25 June 2026

Reference: 250737.03FA

LETTER OF RESPONSE TO DPHI, TWEED SHIRE COUNCIL AND TFNSW REGARDING THE PROPOSED MIXED USE DEVELOPMENT AT 4-8 BELLS BOULEVARD, KINGSCLIFF

KEY

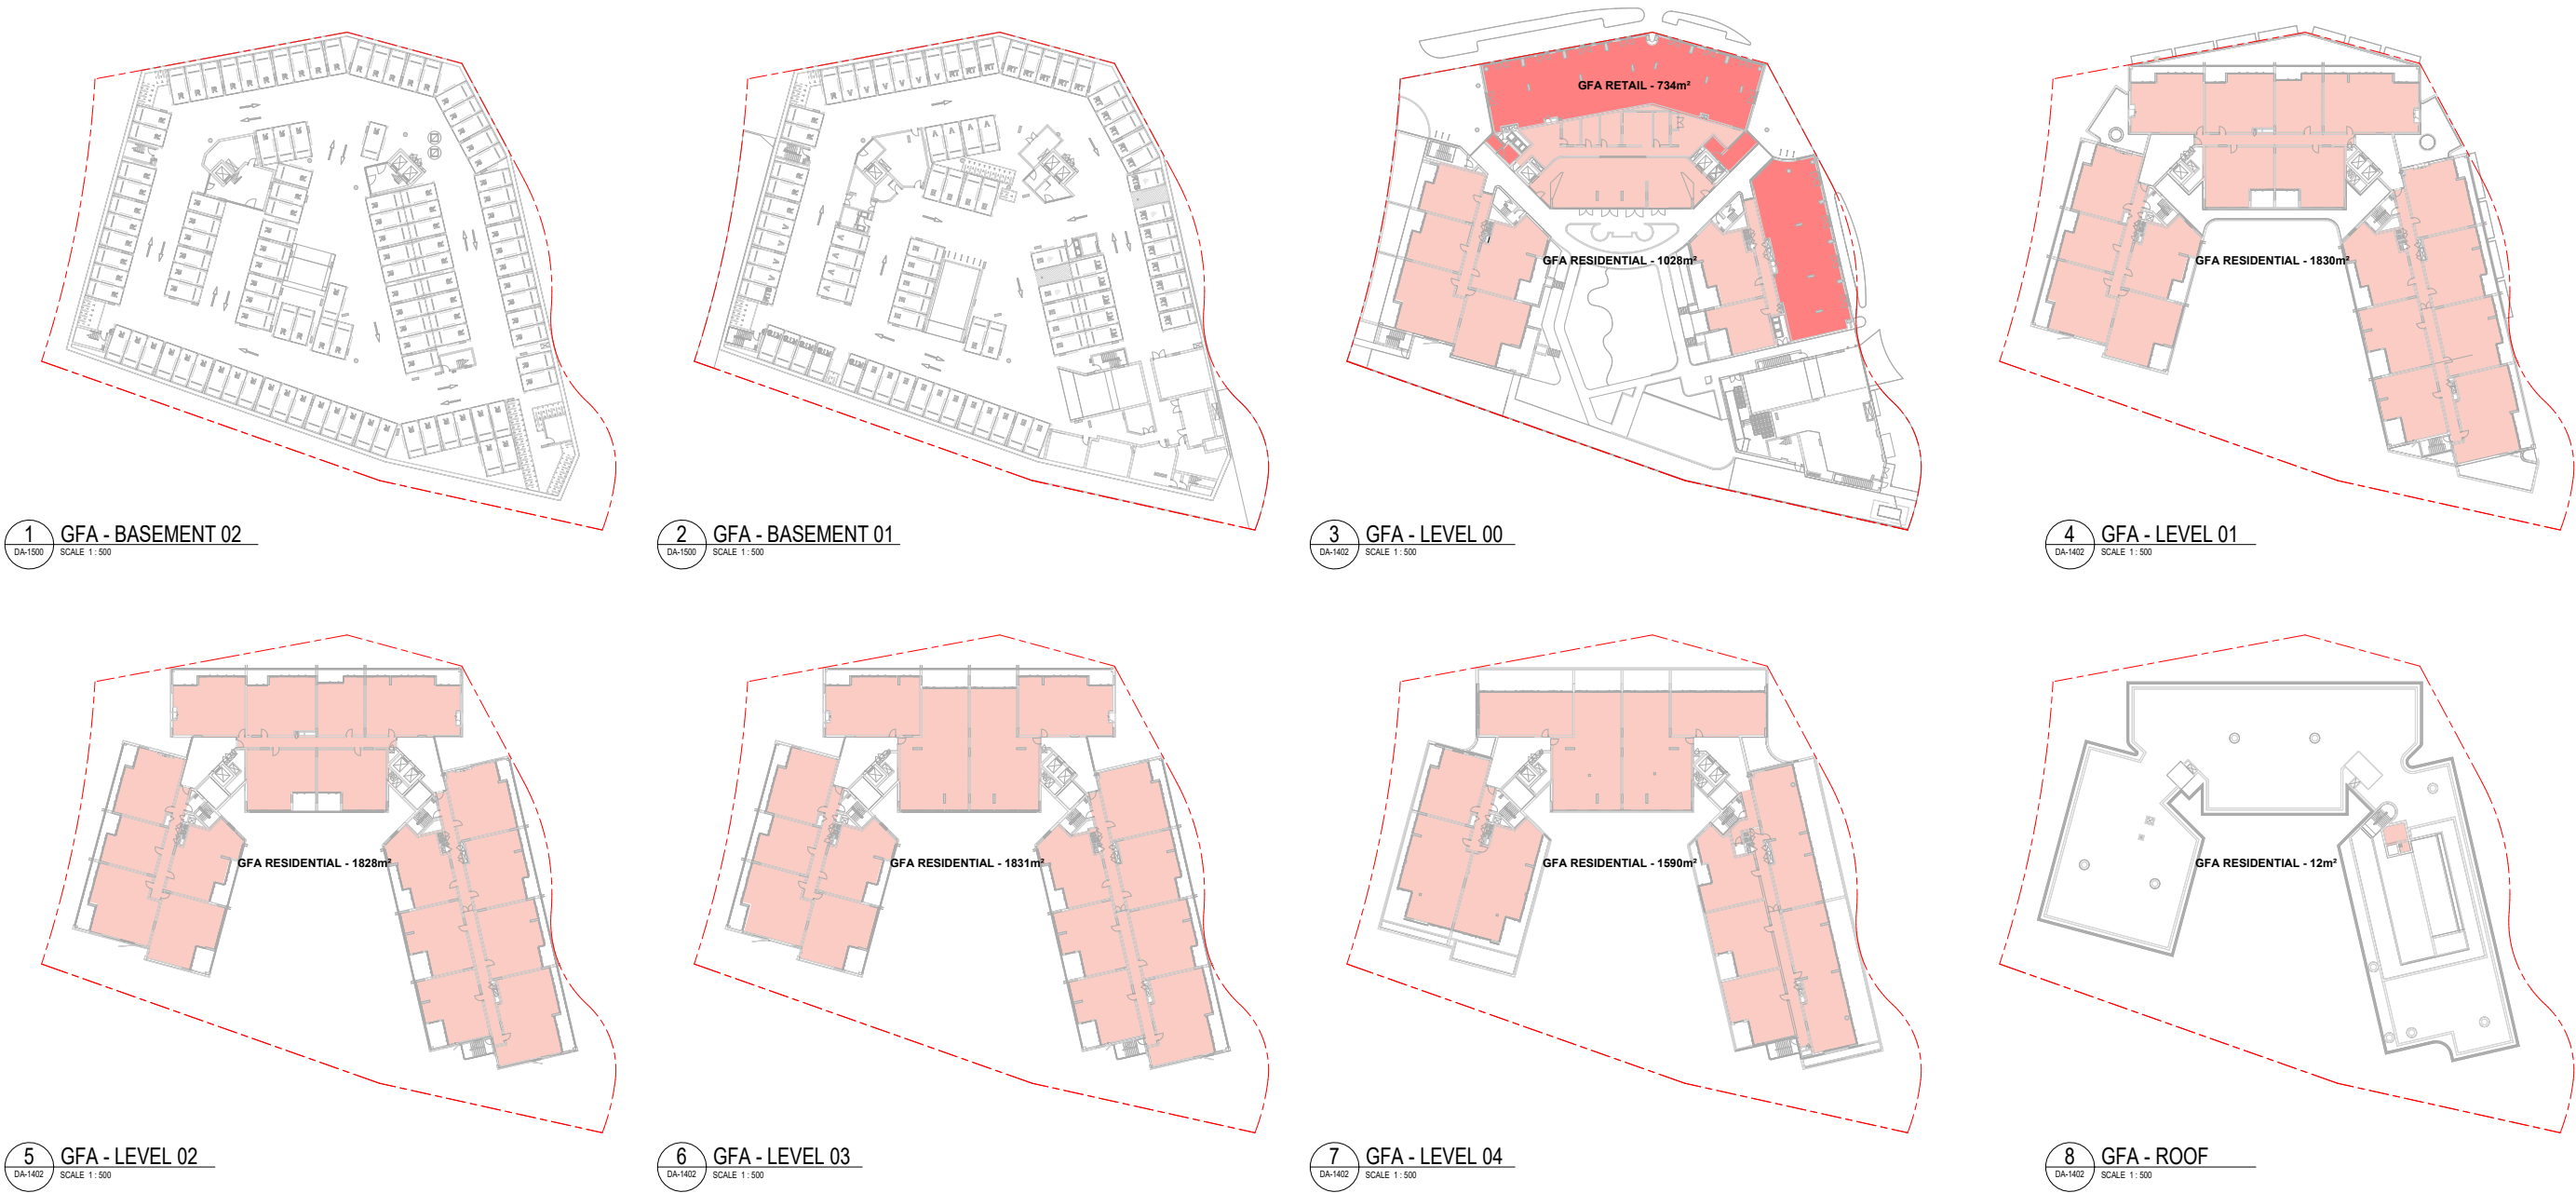
It is recommended that the 24-hour security door within the basement should remain open to allow full forward vehicle movement circulation during all retail trading hours, details for the operational management of the security line door are recommended and implemented for the life of the development

Council recommends that the 27 easement spaces be physically delineated signposted, unrestricted 24/7, and accessible to the public without the need for building access devices. Wayfinding signage shall be installed at an appropriate location within the road reserve to clearly direct vehicles and inform the public of the availability and access arrangements.

MTE Response: The arrangement of the easement car parking spaces has been amended to ensure there is no blind aisles associated with the 24-hour security doors within the basement.

MTE Response: The 27 easement car parking spaces are physically separated from all other parking spaces within the basement to ensure unrestricted 24/7 access. The management of this access is subject to the buildings plan of management. Wayfinding signage can be installed within the road reserve, informing the public of the availability of parking, typical dark blue parking wayfinding signage can be provided. The above can be addressed as a condition of consent and no further revised design changes are required.

It is noted that the location and arrangement of the easement car parking have been adjusted to provide improved circulation and 24/7 access.

OVERALL SECTION A
SCALE 1:500

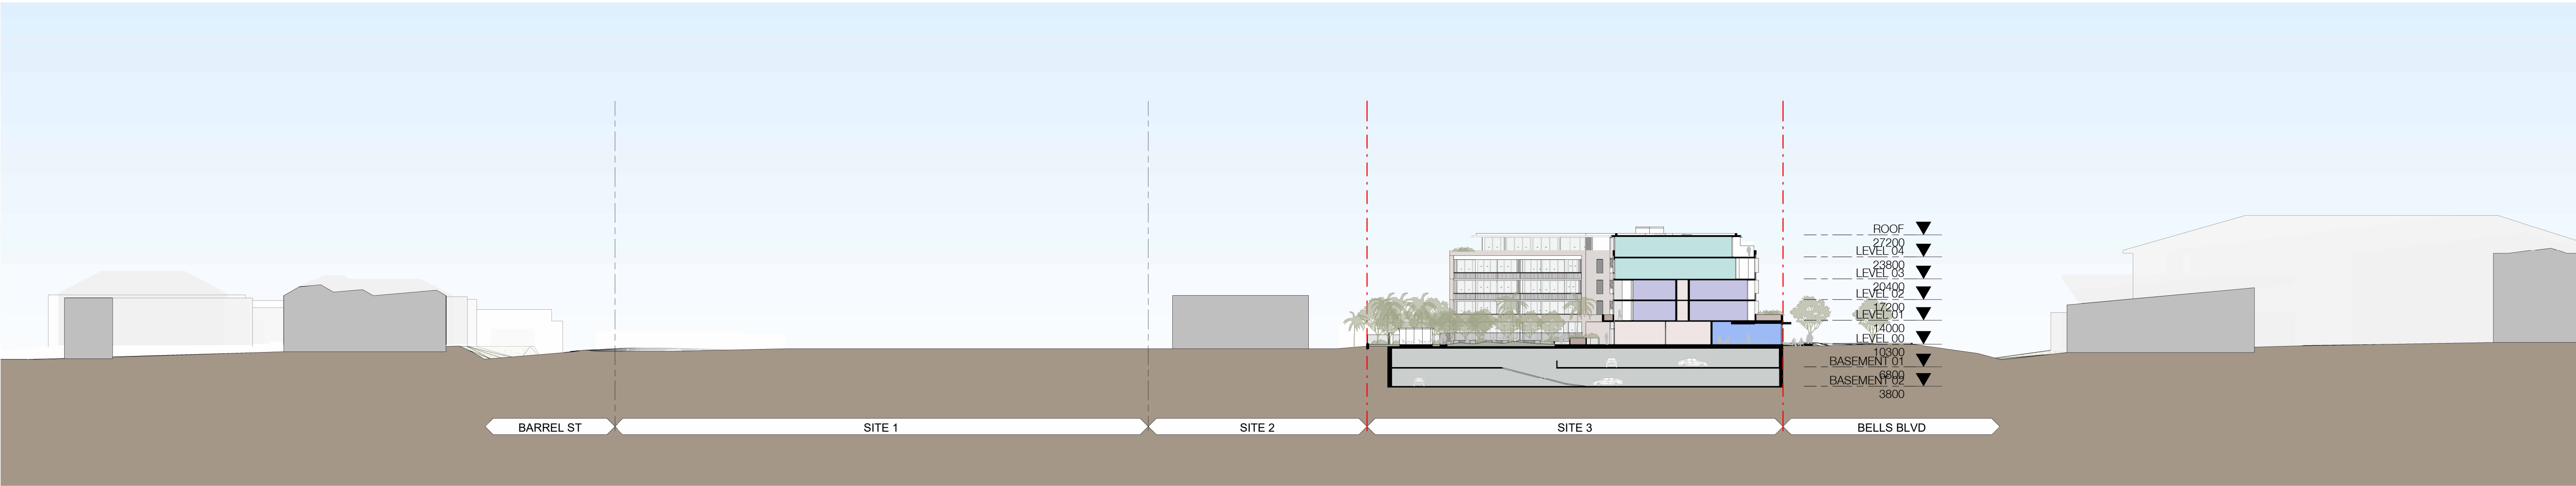
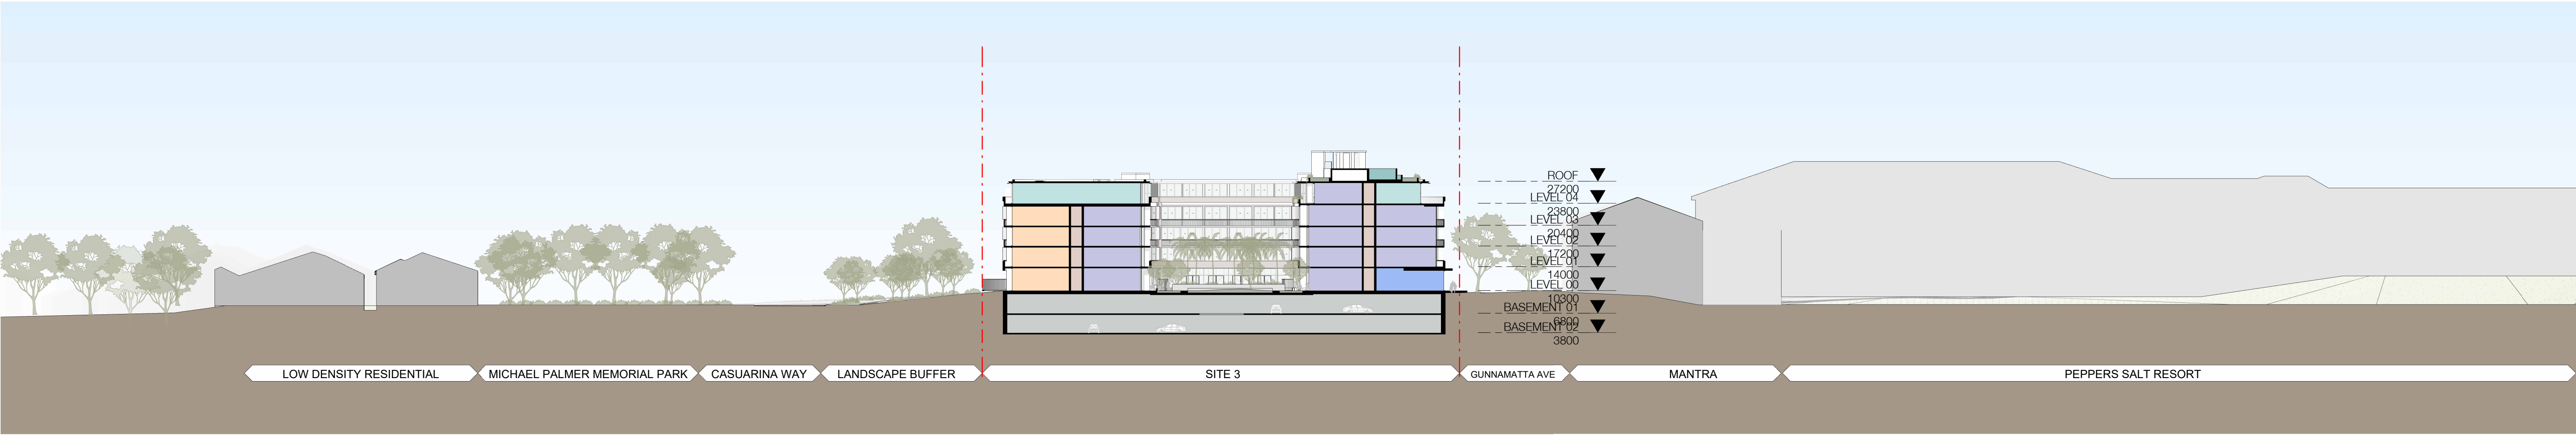
It is unclear if there is adequate headroom available or residential carparks that are located underneath the basement carparking access ramp. The section diagrams nor the Traffic Impact Assessment provide detail on this headroom and it is recommended that this be provided.

MTE Response: A minimum headroom of 2.2m is provided for the relevant residential car parking spaces provided under the access ramp. Sections of the ramp indicating the available headroom is provided in **Annexure A** for reference and confirmation.
